Re: Ideal BSP Early Grading – *Tech Review 1*
PA22039 & CAR22004

RE: Ideal BSP – SEPA/ Early Grading, File#PA22-039
Requesting SEPA for early grading
14925 Smokey Point Boulevard & Parcel #'s 31053300201500, 31053300202200,
31053300202300, 31053300202400, 31053300202500, 31053300300600

TO: Chris Holland, Planning Manager
FROM: Brooke Ensor, NPDES Coordinator
DATE: 9/19/2022
SUBJECT: PA22-039 Ideal BSP – Early Grading

EARLY GRADING CLEARING, GRADING & TESC PLAN

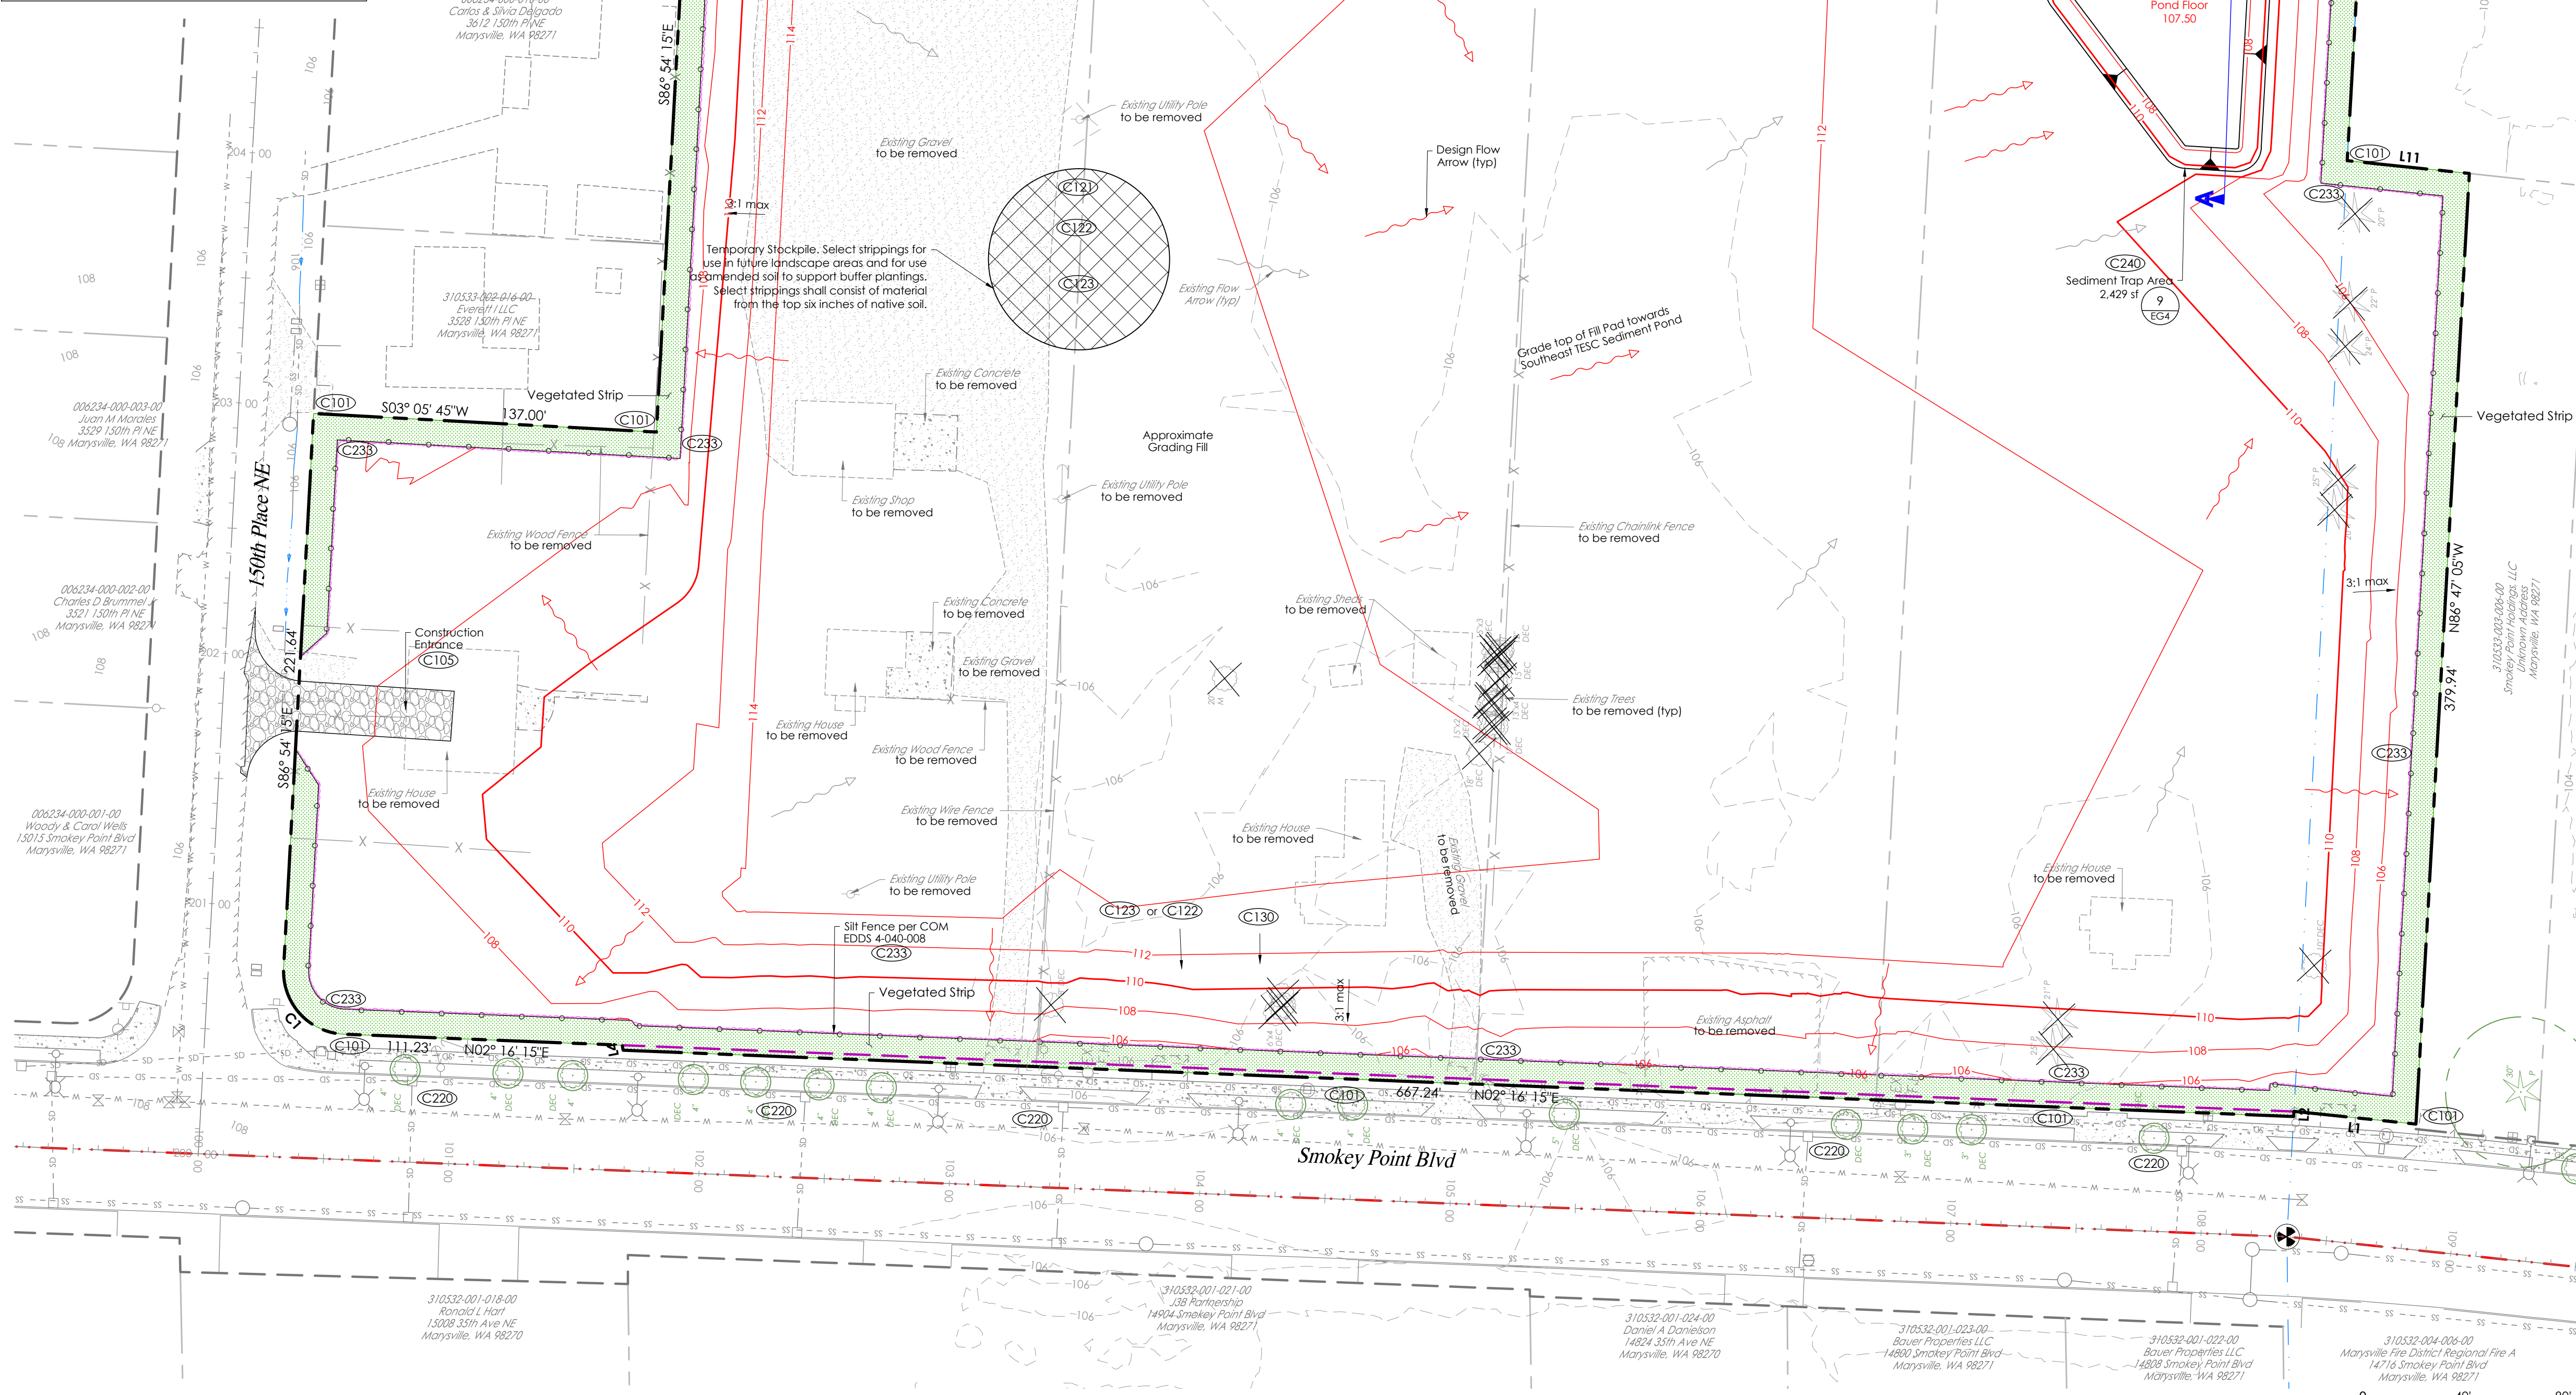
- b. Remove the proposed "construction entrance" from 150th Place NE and move to Smokey Point Boulevard.
 - c. There are some trees located near the eastern edge of the site that are proposed to be retained, however, grading appears to be occurring in that area. Please review and amend as necessary.

- d. As noted above the ditch located between APN's 31053300201500, 31053300202500, 31053300300600 & 31053300302500 are hydrologically connected to a fish bearing stream and are considered "Water of the US." The applicant will be required to obtain a permit from the Corps or the grading plans shall be amended so that no grading activity occurs within he ditch.
